In relation to the application mentioned above, Council is still in the process of finalising a complete submission and we would appreciate for Council to be given until 13 February 2025 to be able to formally submit the submission.

In the meantime, Council raises the following issues and points about the application that would be detailed in the forthcoming submission:

Figure 10 Proposed eastern elevation

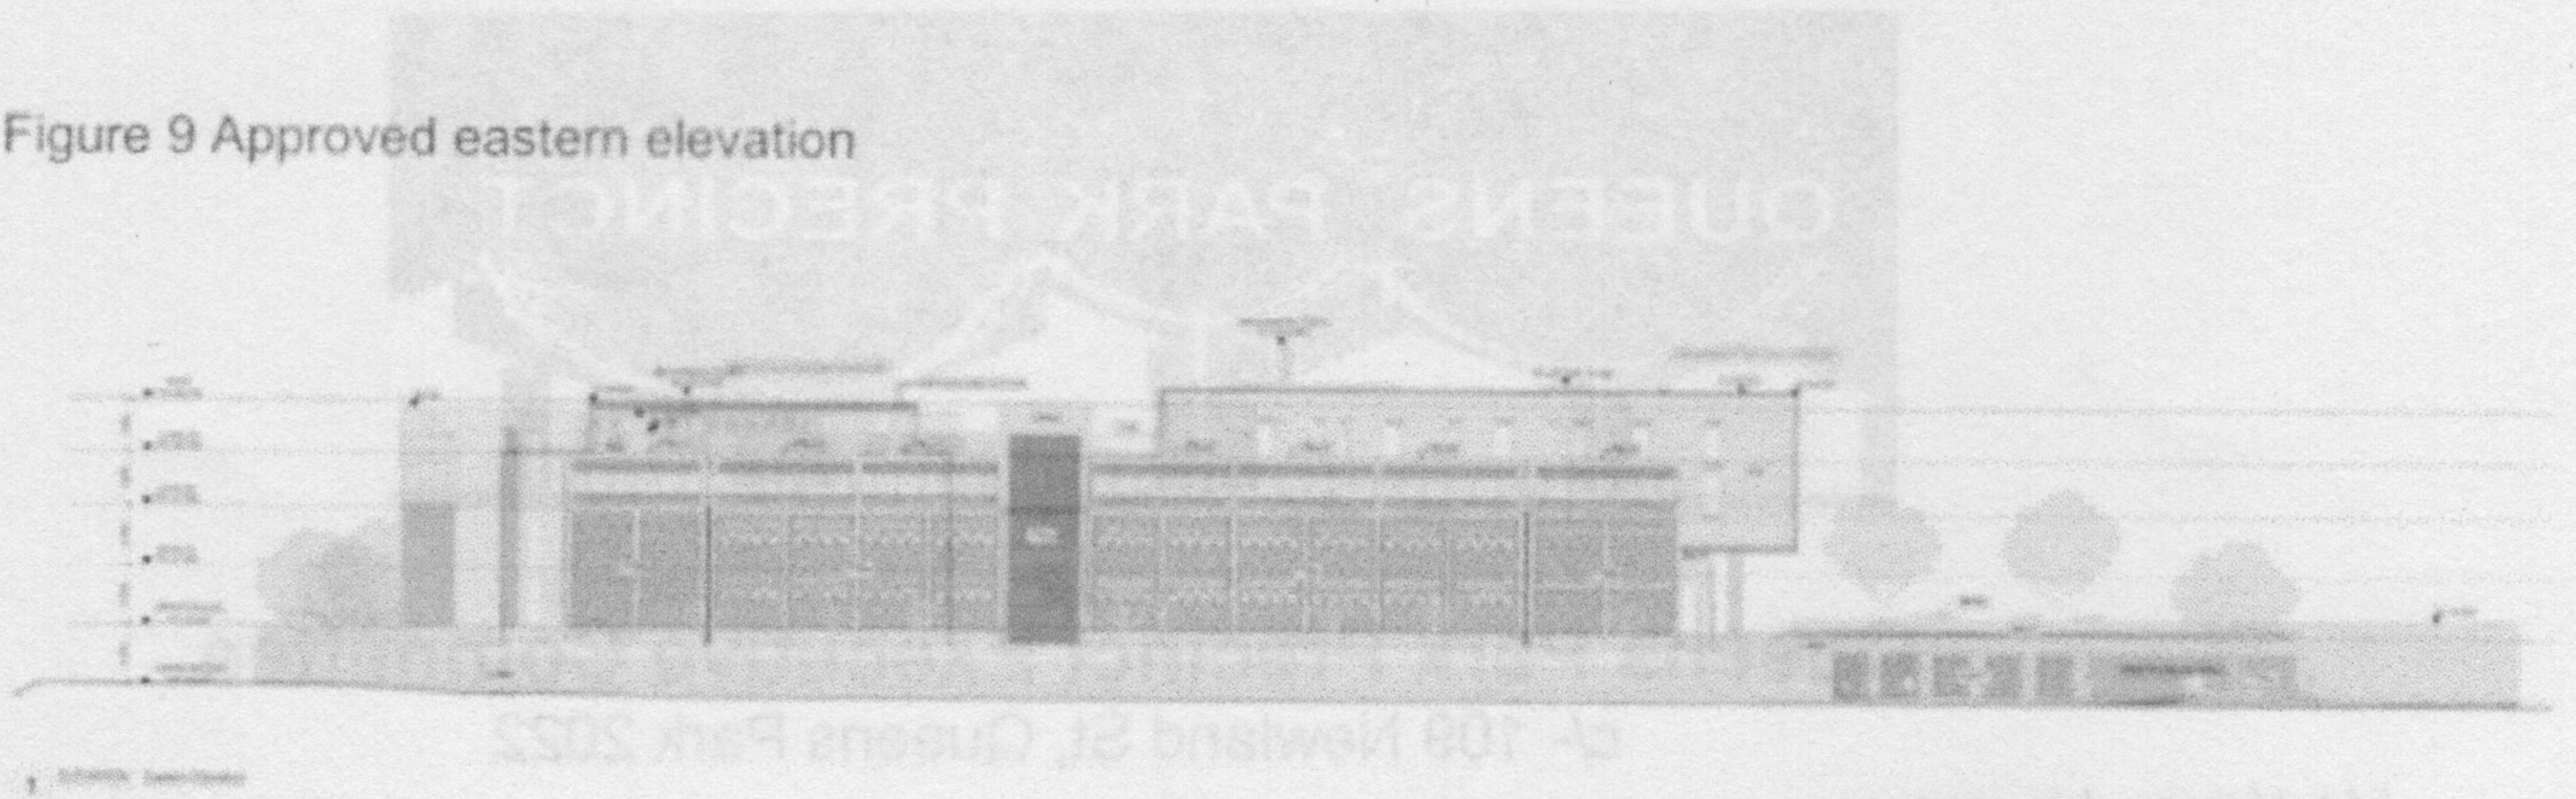
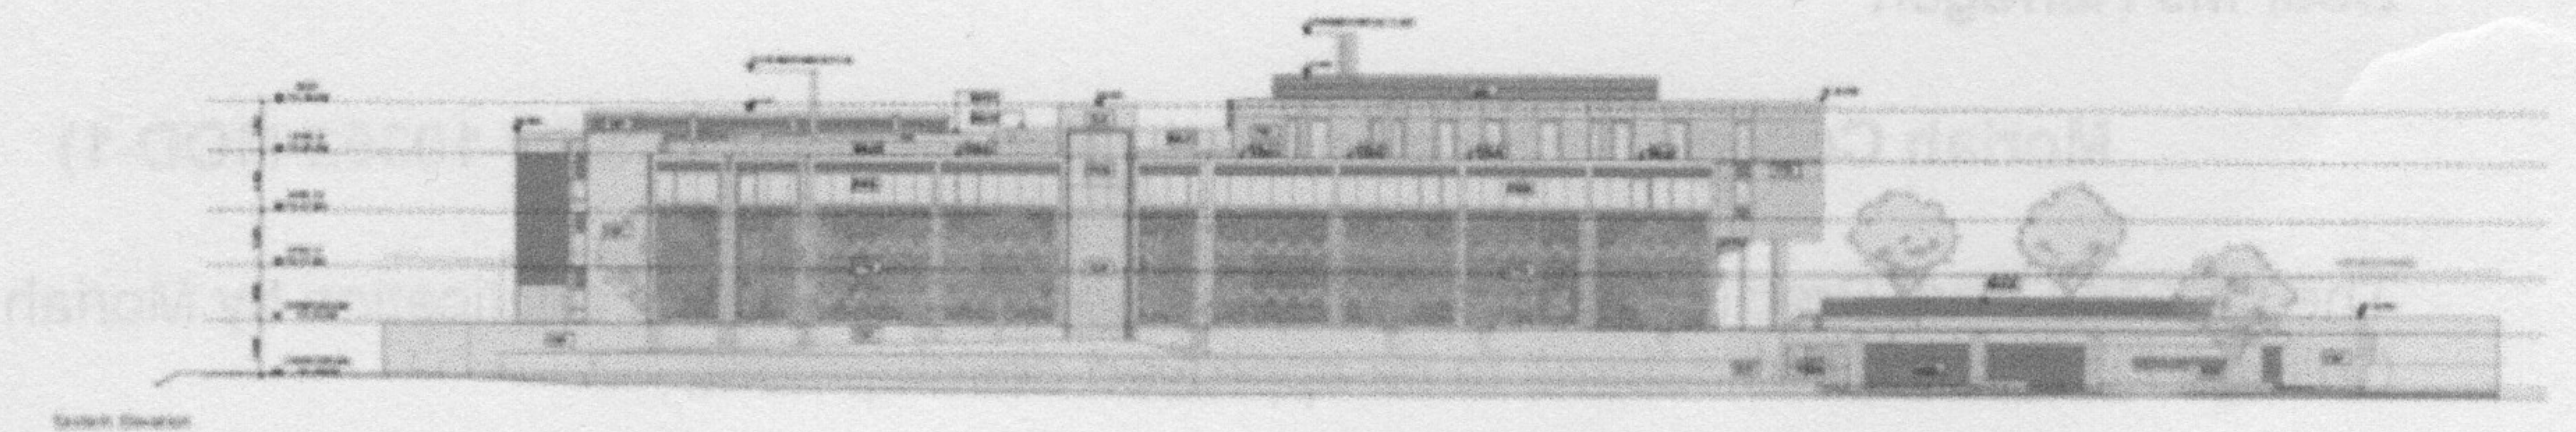
- Biodiversity, particularly impacts of the proposed realignment of the carpark on the adjacent Eastern Suburbs Banksia Scrub reservation.
- Tree Management.
- Landscaping.
- Streetscape impact of new booster assemblies on Queens Park Road and substation kiosk on York Road.
- Built form changes.
